Your ref:
Our ref: 21/01993/F
Please ask for: Mrs Rebecca Bush
Direct dial: 01553 616825
Direct fax: 01553 616652
E-mail: borough.planning@west-norfolk.gov.uk

Details: **Demolition of existing side extensions. Construction of 2 storey side extension and single storey front porch at Lumbertubs 7 Wheatley Drive North Wootton King's Lynn Norfolk**

SECTION A-A
SCALE 1:100 AT A1

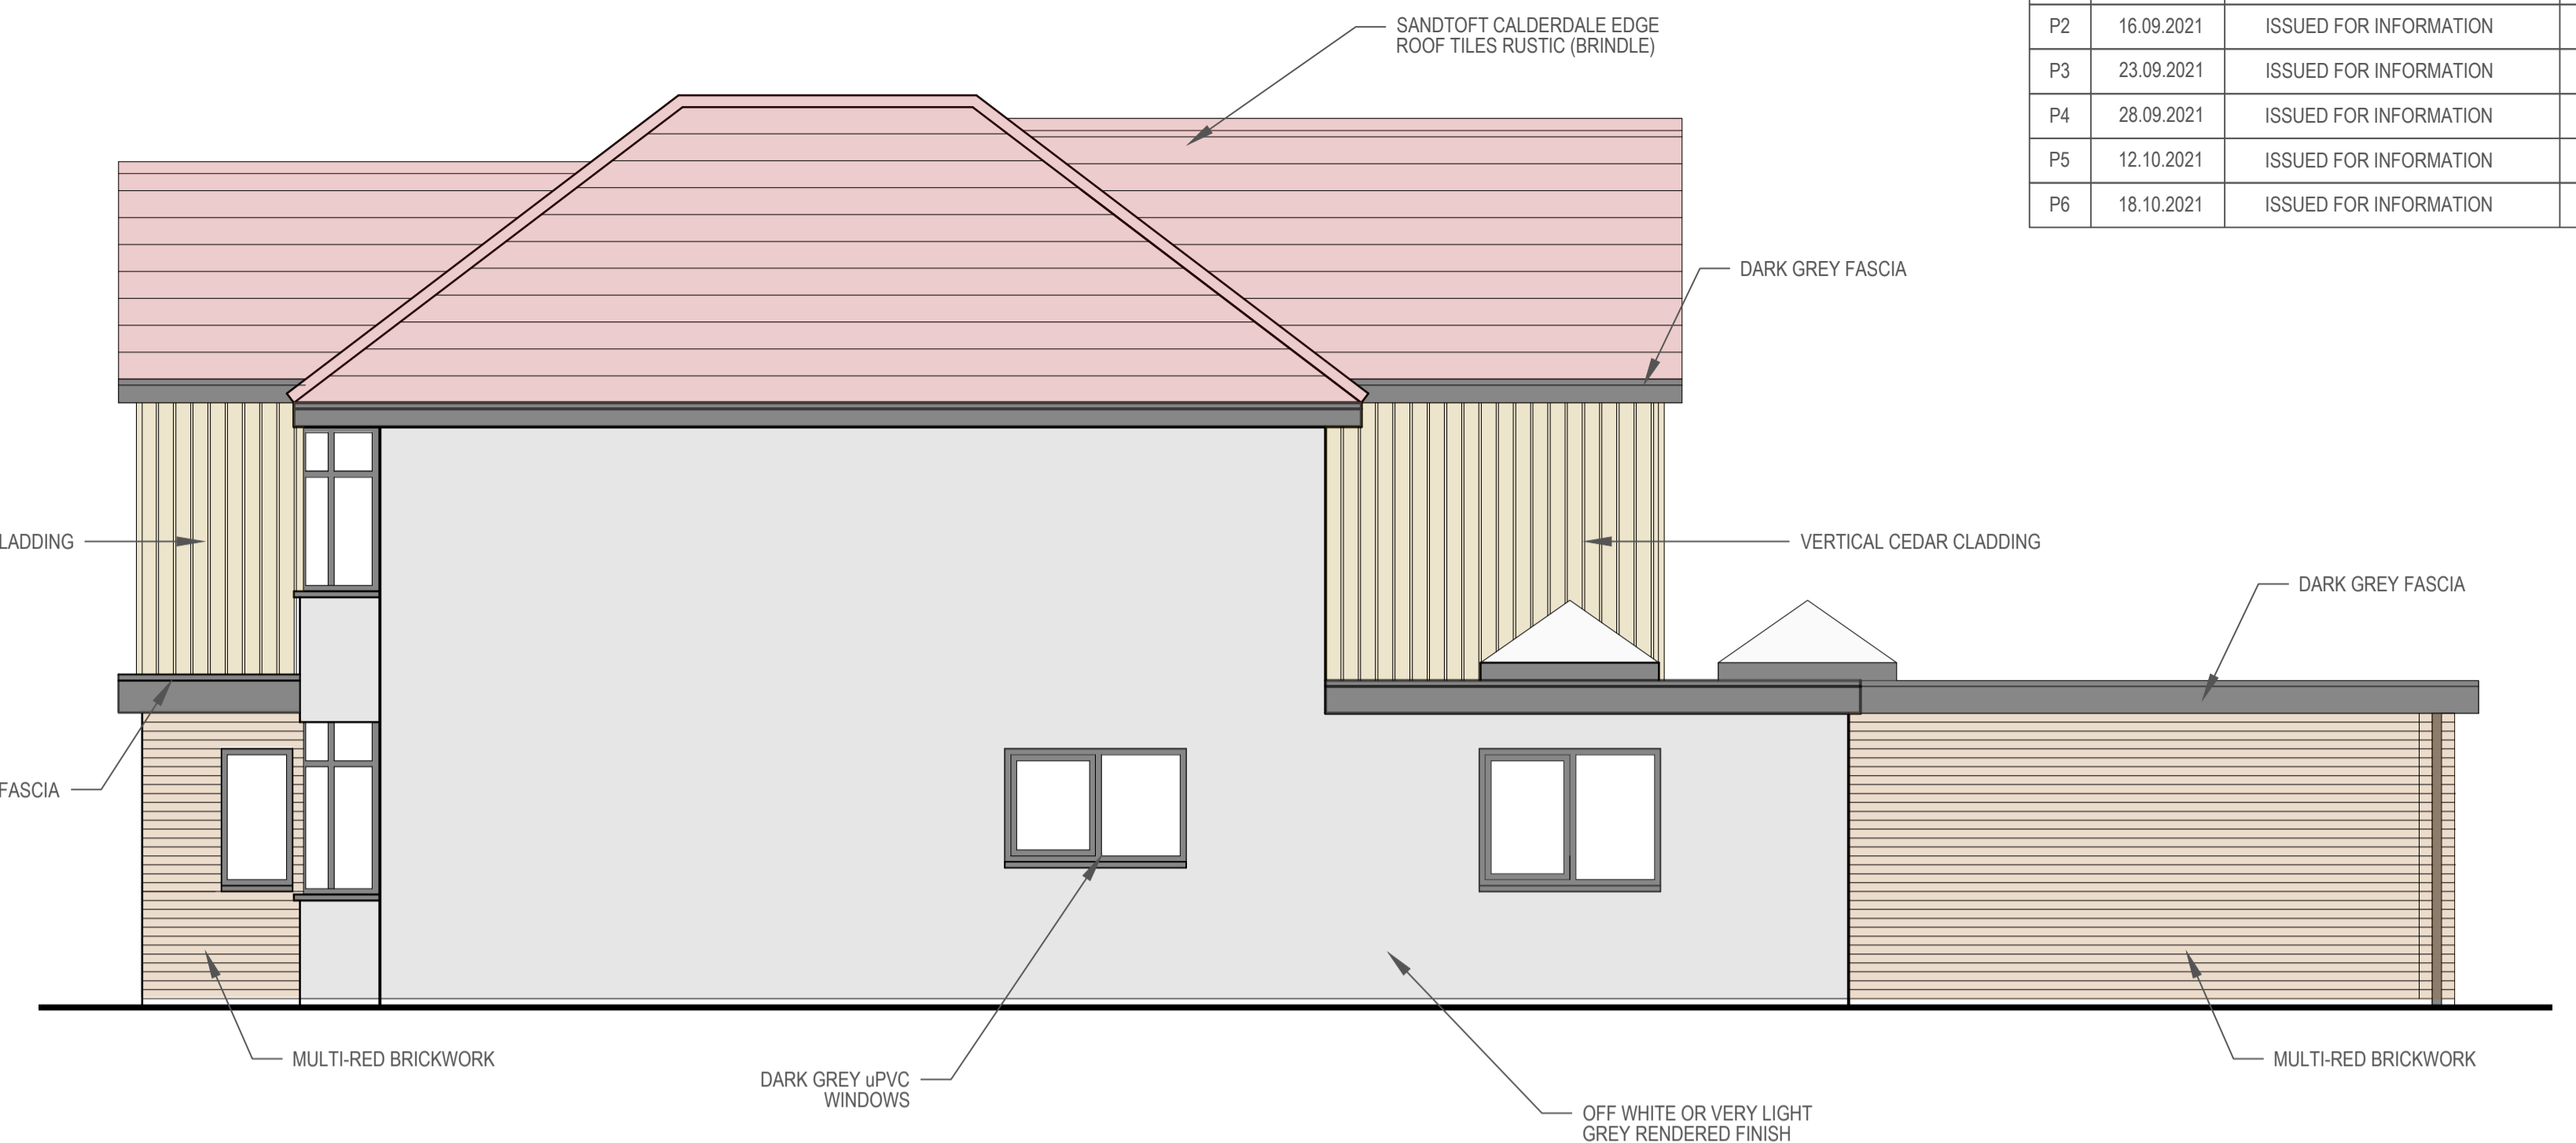
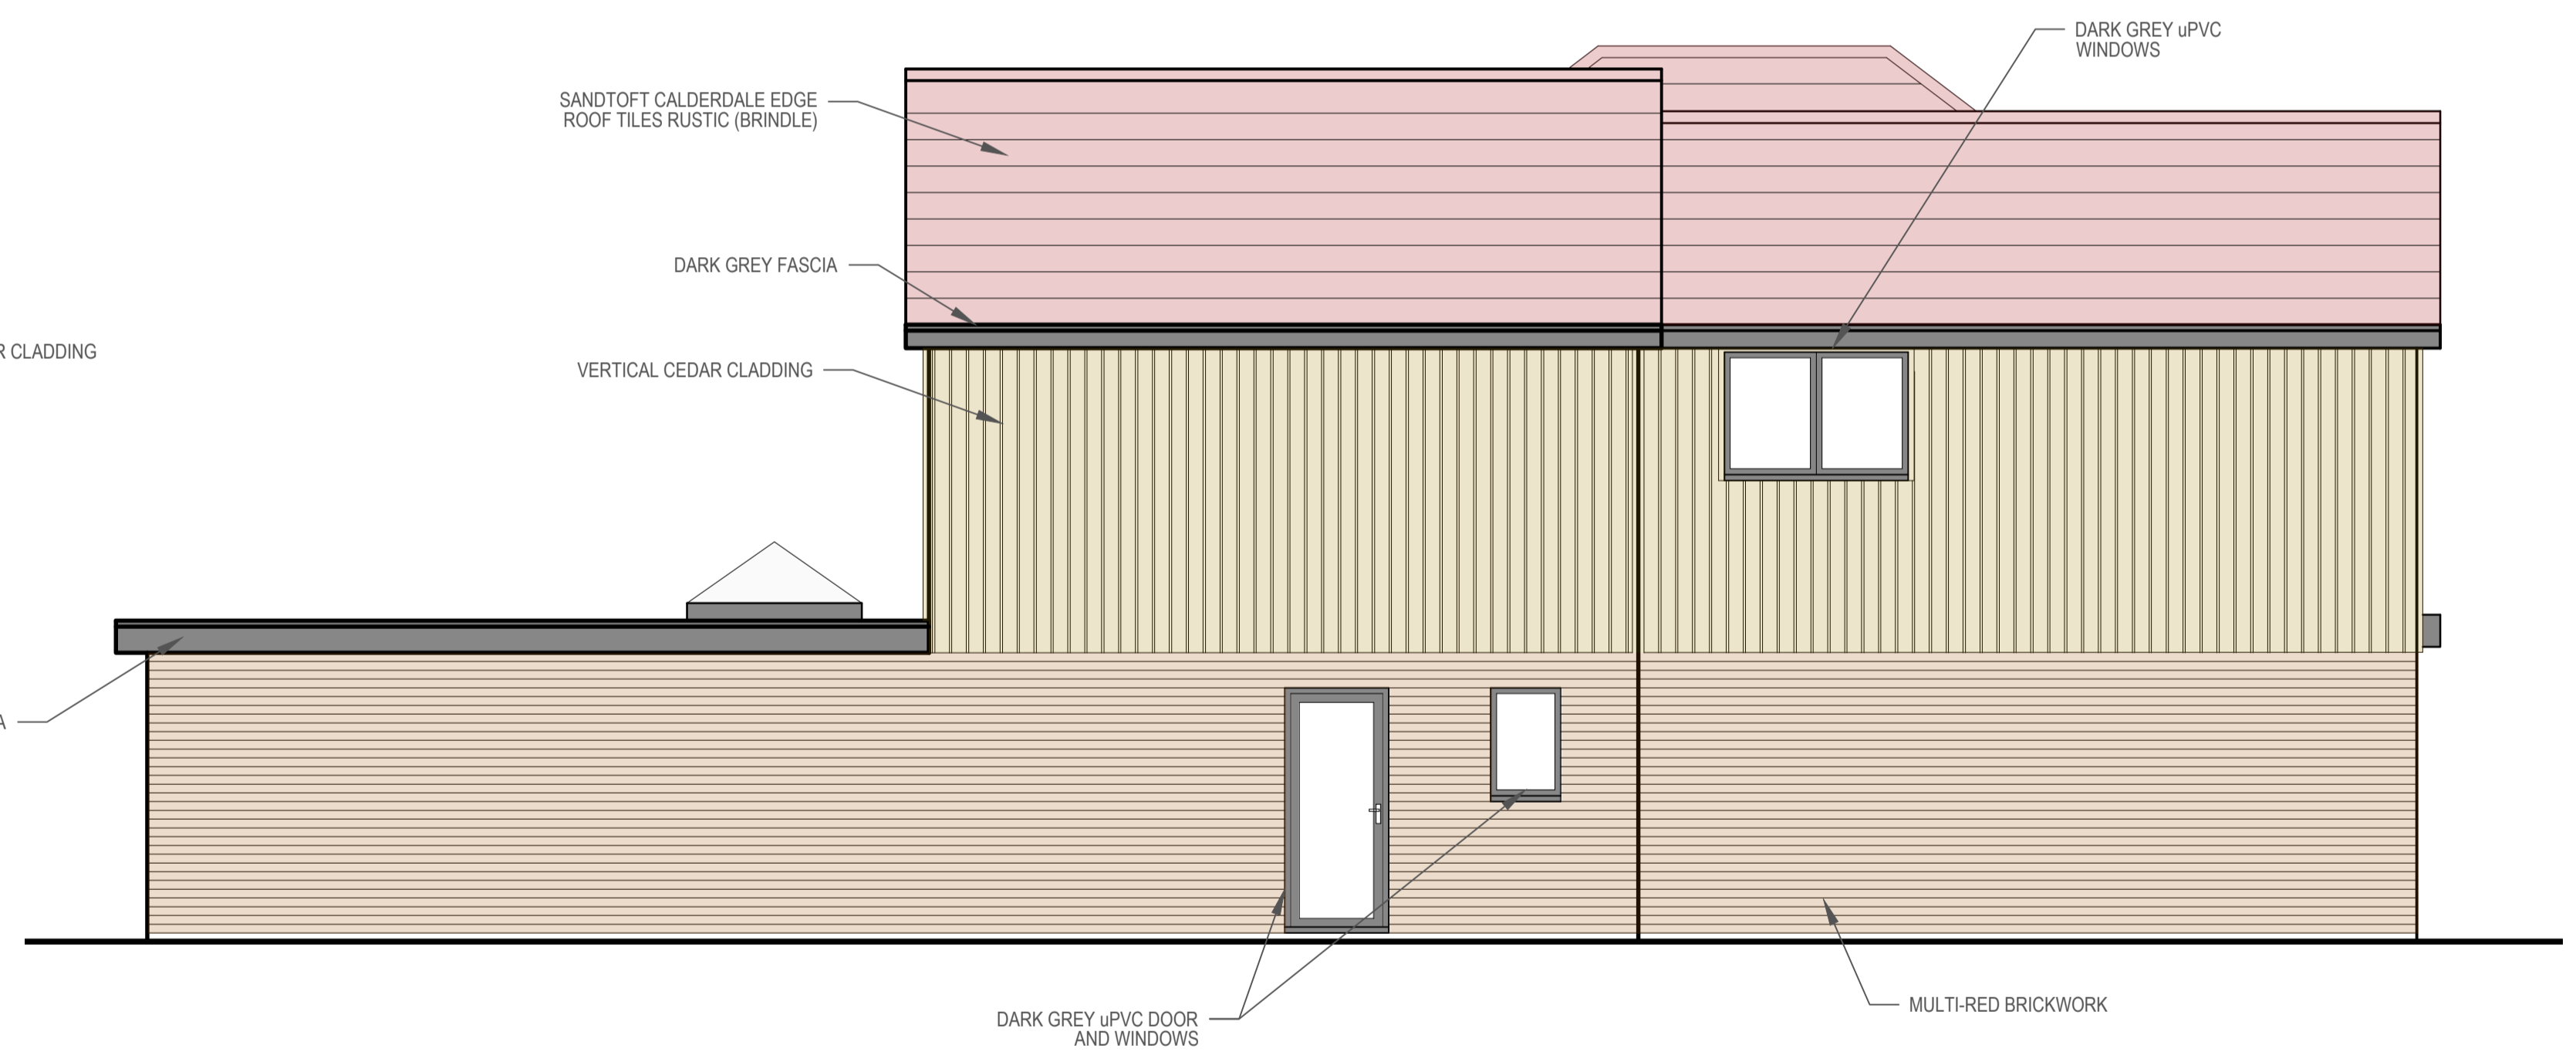
1. We will require a block plan/roof plan to a scale of 1:500 or 1:200 showing site boundaries and the new work.
2. Please provide four copies of a drawing, to a recognisable scale, showing a section through the new extension.
3. In accordance with the National Validation Checklist, which became mandatory on 6 May 2008, we will require information regarding site levels. If site levels are to change, please provide four copies of a site survey drawing, alternatively, if site levels are to remain unchanged, this can be annotated on the relevant plan or advised in writing.
4. As the property lies within an area at risk to flooding, please complete the simplified Matrix and return it. The Matrix can be found at https://www.west-norfolk.gov.uk/info/20173/information_for_planning_agents/231/flood_risk_information
